DELEGATED DECISION TO DETERMINE PLANNING APPLICATIONS

Reference No:	2024/62/93503/W
Site Address:	New Hagg Barn, Oldfield Road, Honley, Holmfirth, HD9 6RN
Description:	Installation of an air source heat pump, enlargement of existing window, new external timber decking and conservation roof lights and associated works (Listed Building)
Recommending Officer:	Joanna Rednall

DECISION – Full Conditional Permission

Drawing Title EXISTING & PROPOSED ELEVATIONS 2

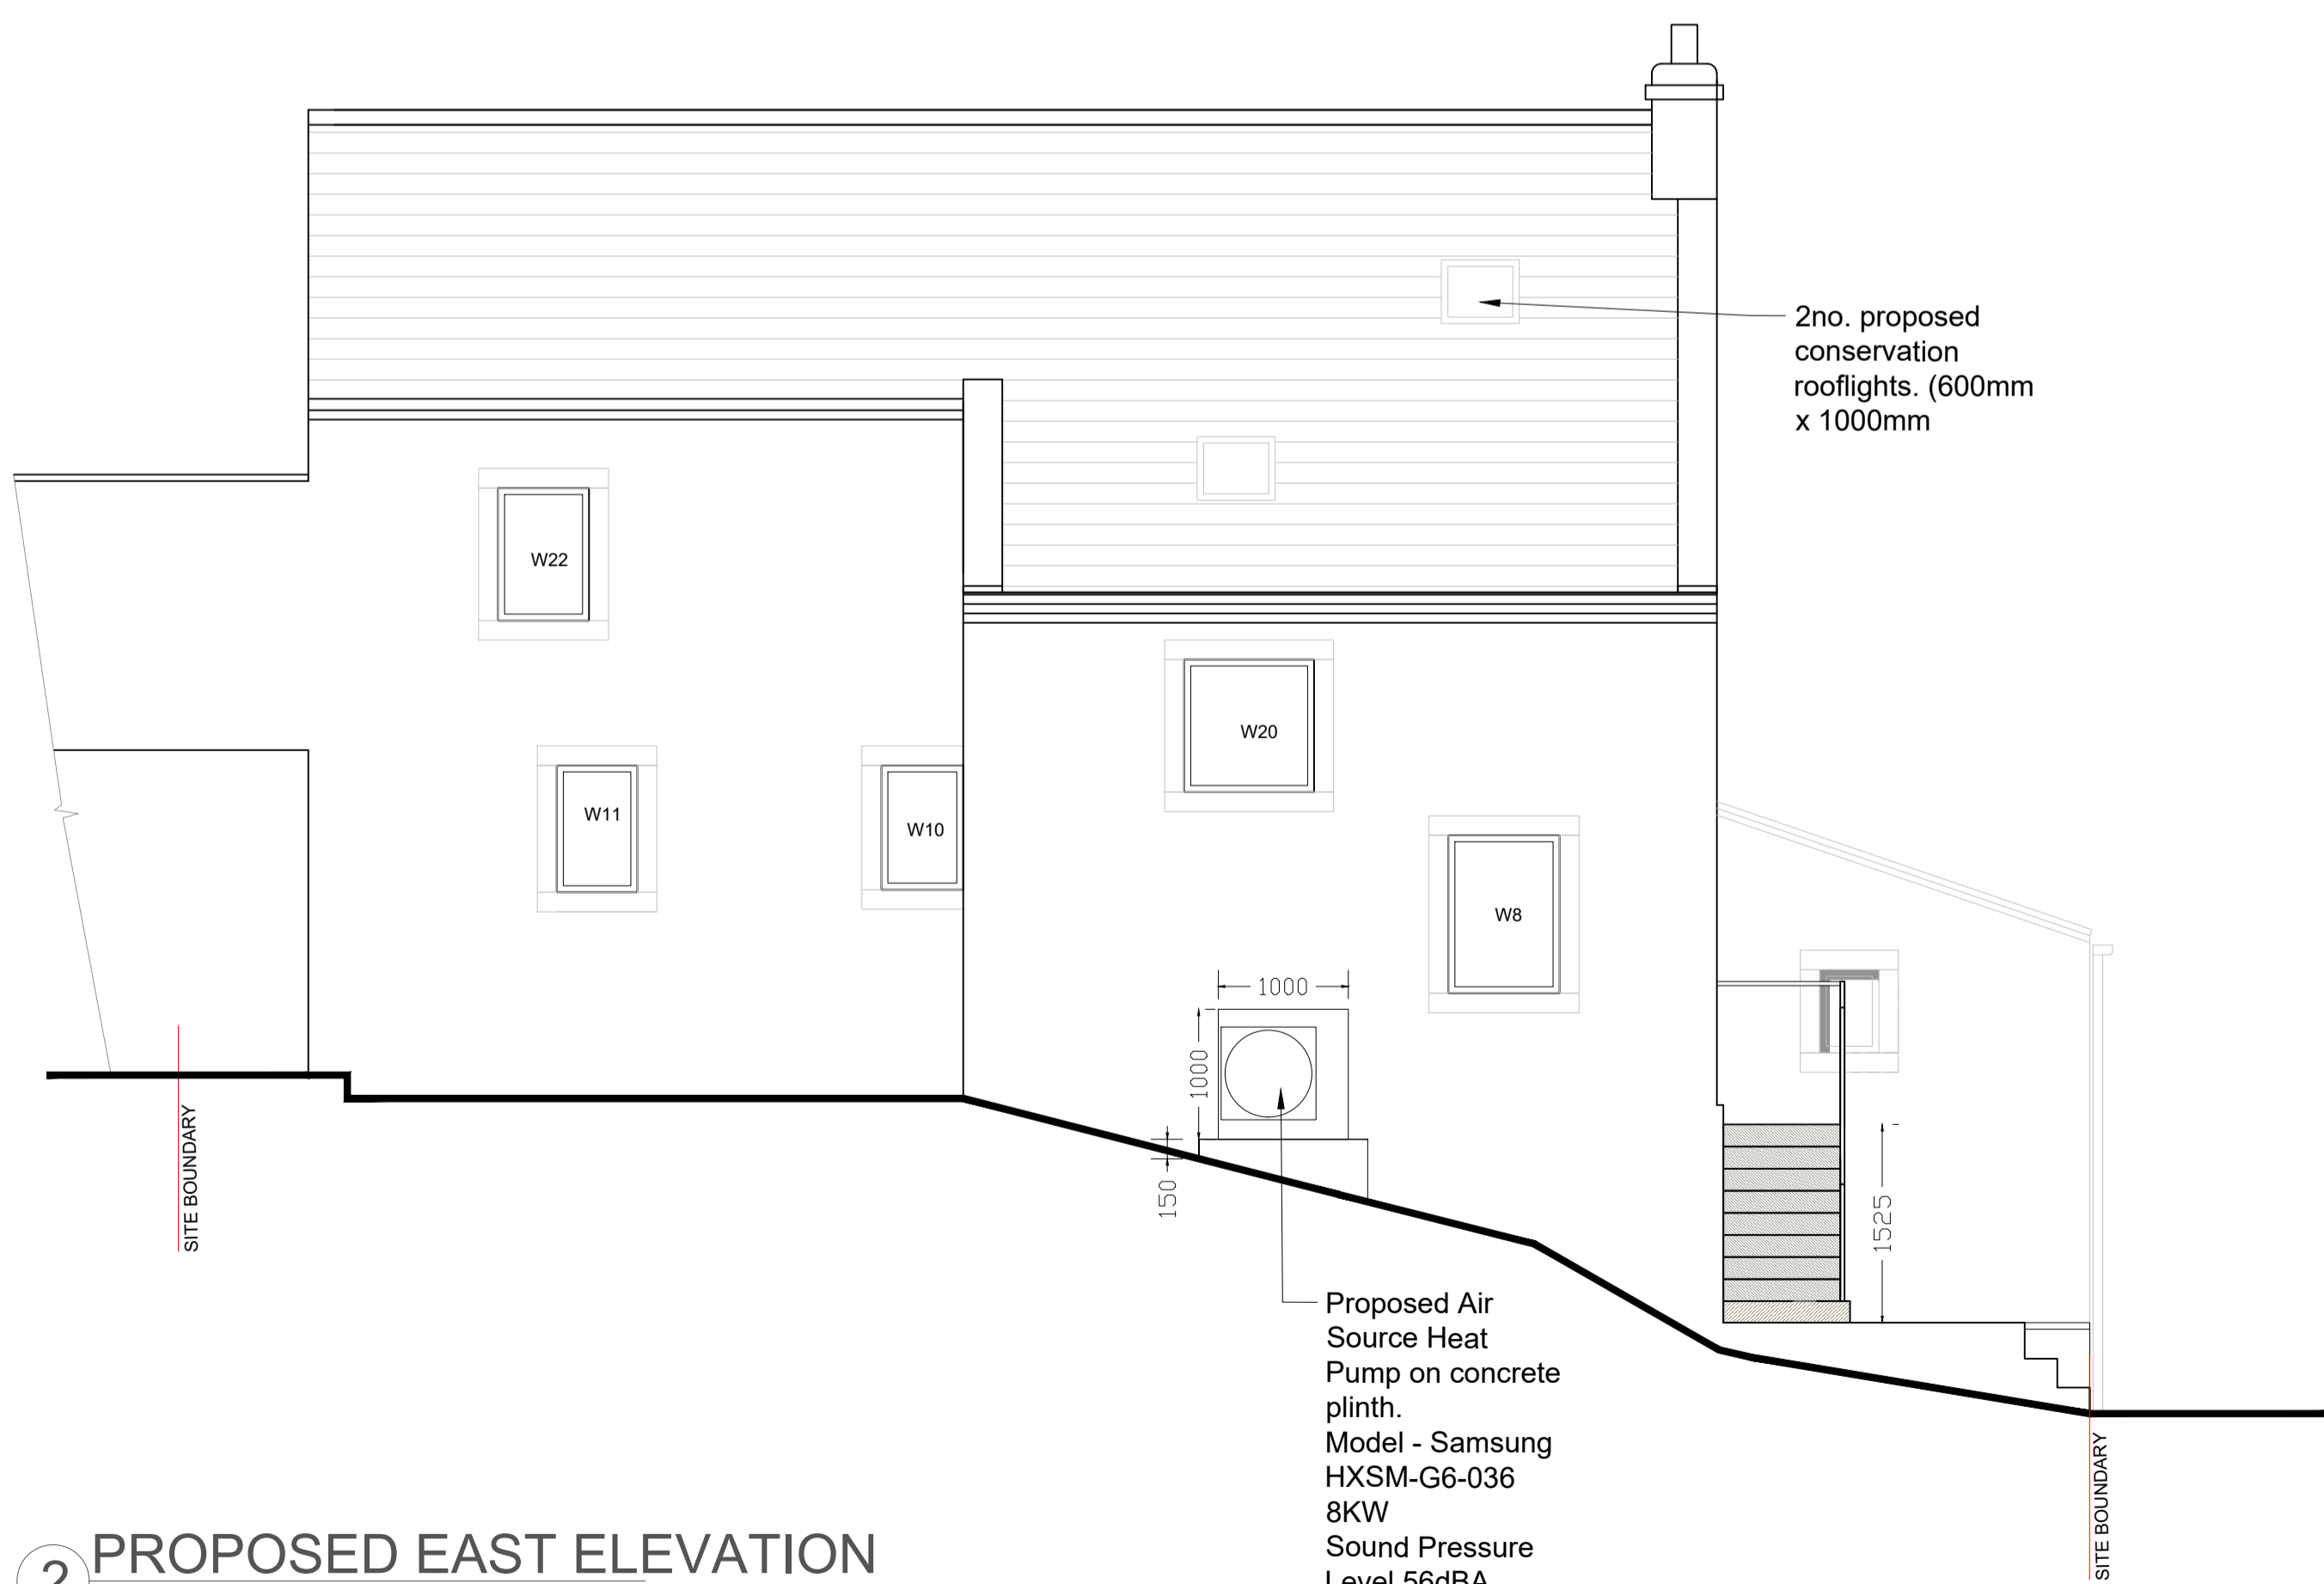
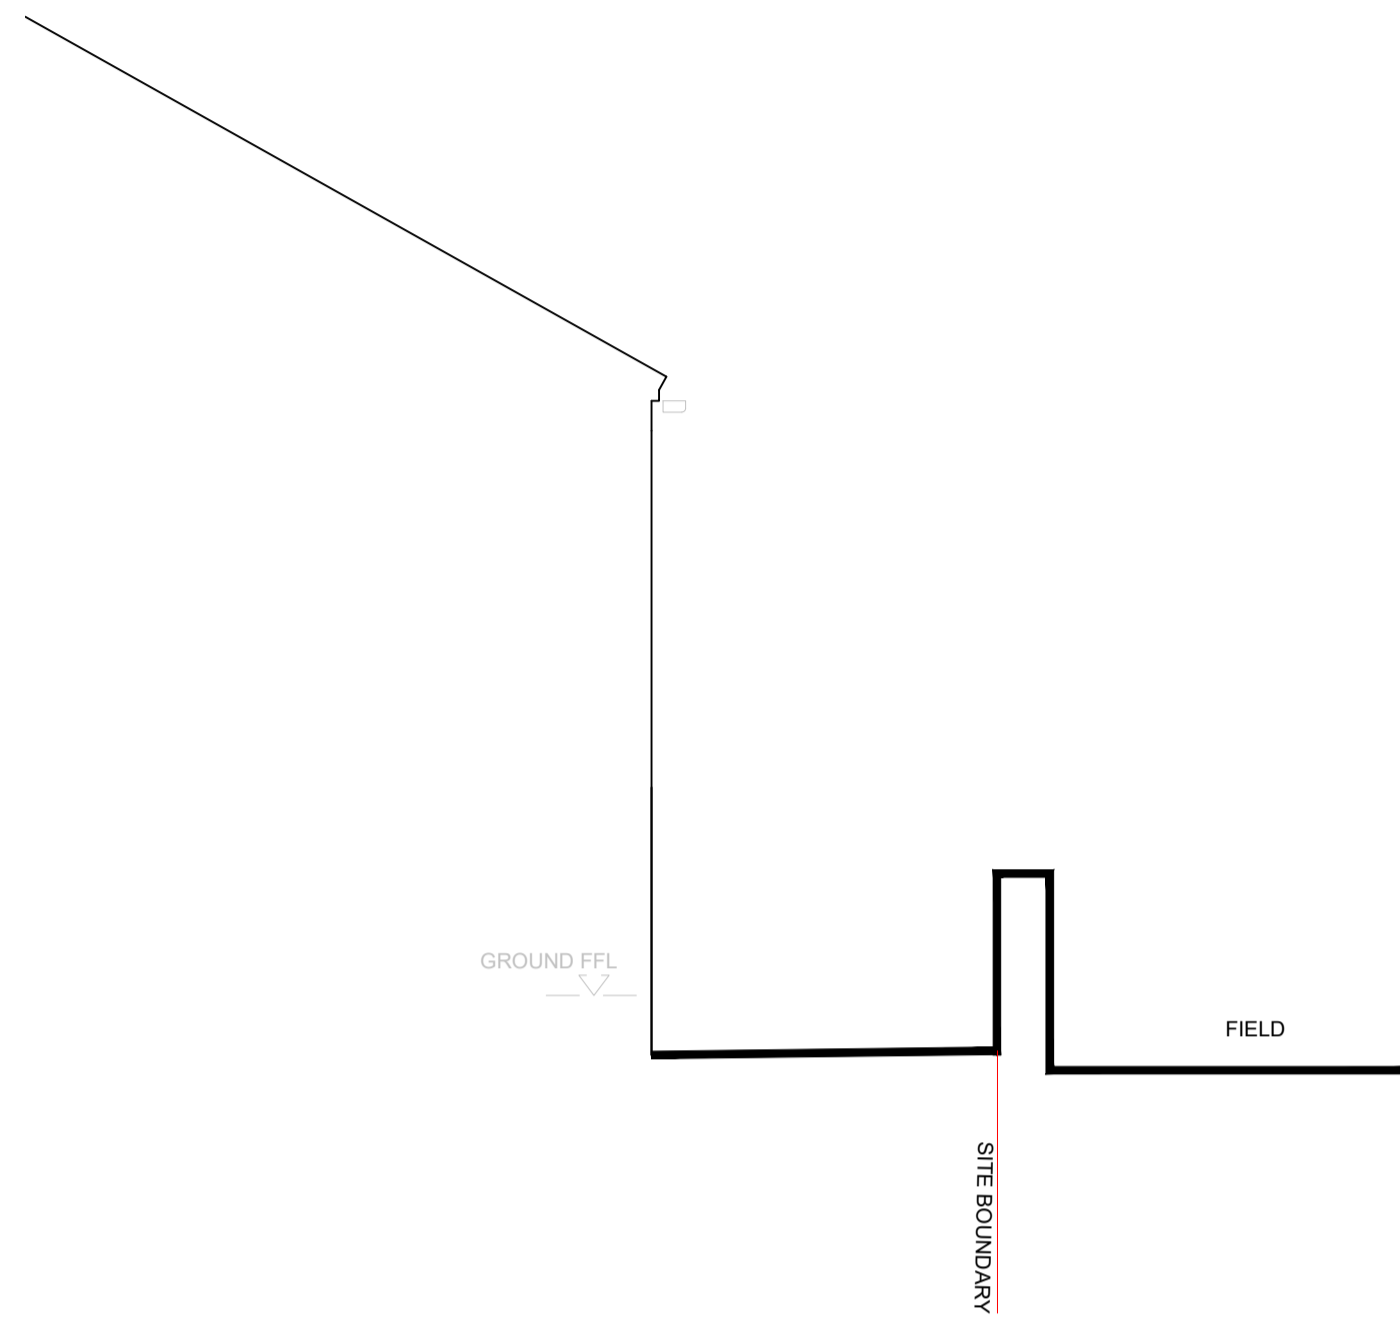
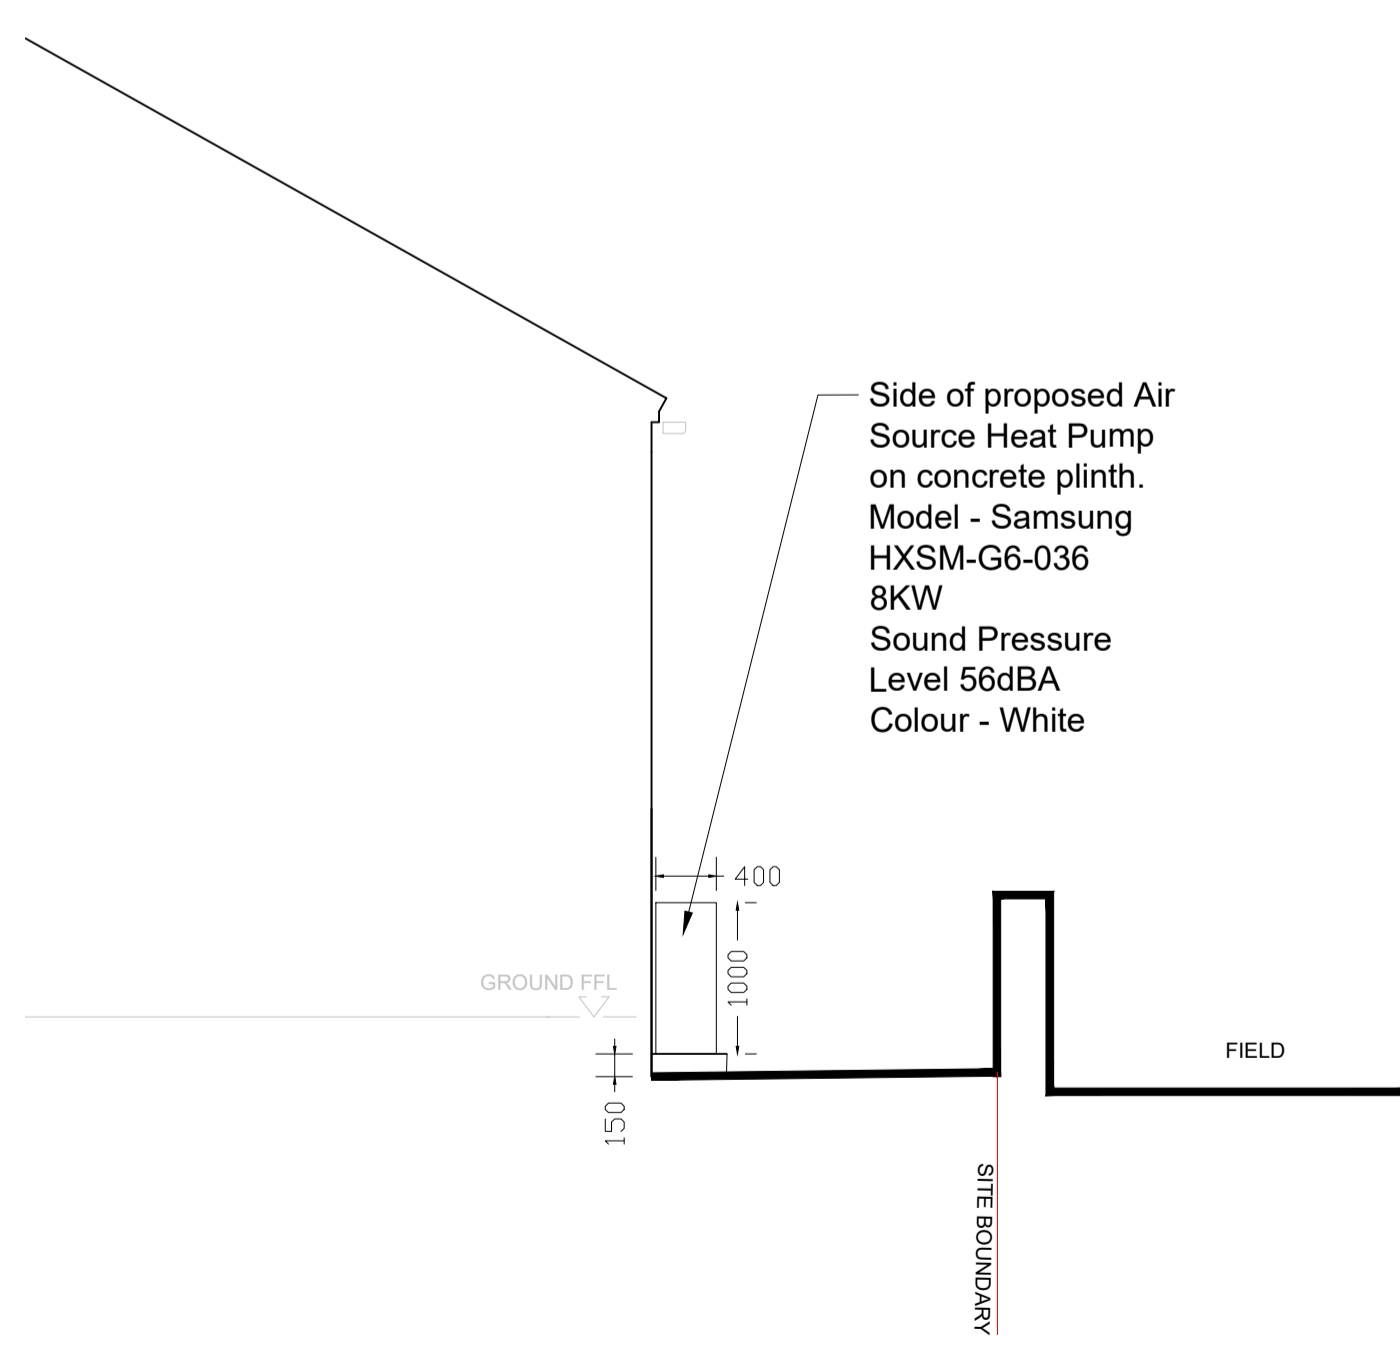
KC Conservation and Design: There is no objection to the proposed air source heat pump or rooflights. However, officers raised concerns regarding the extent of the originally proposed decking, as it would have introduced excessive residential paraphernalia that was inconsistent with the character of the former barn and would have detracted from its historic interest. The extent of decking has since been reduced, and officers consider the revised plans to be more acceptable.

4. Notwithstanding the submitted details, the Air Source Heat Pump annotated upon drawing 2419 / 105 Rev A shall be installed in accordance with the noise standards set out in the document 'MCS Planning Standards for Permitted Development Installations of Wind Turbines and Air Source Heat Pumps on Domestic Premises' and retained as such thereafter.

Amendments were sought to reduce the scale of the raised decking in response to the comments from the Council's Conservation and Design Officer. Amended plans were received 28th March 2025 which were deemed acceptable and the application has progressed on this basis. The amended plans were not re-publicised as these did not fundamentally change the development applied for.
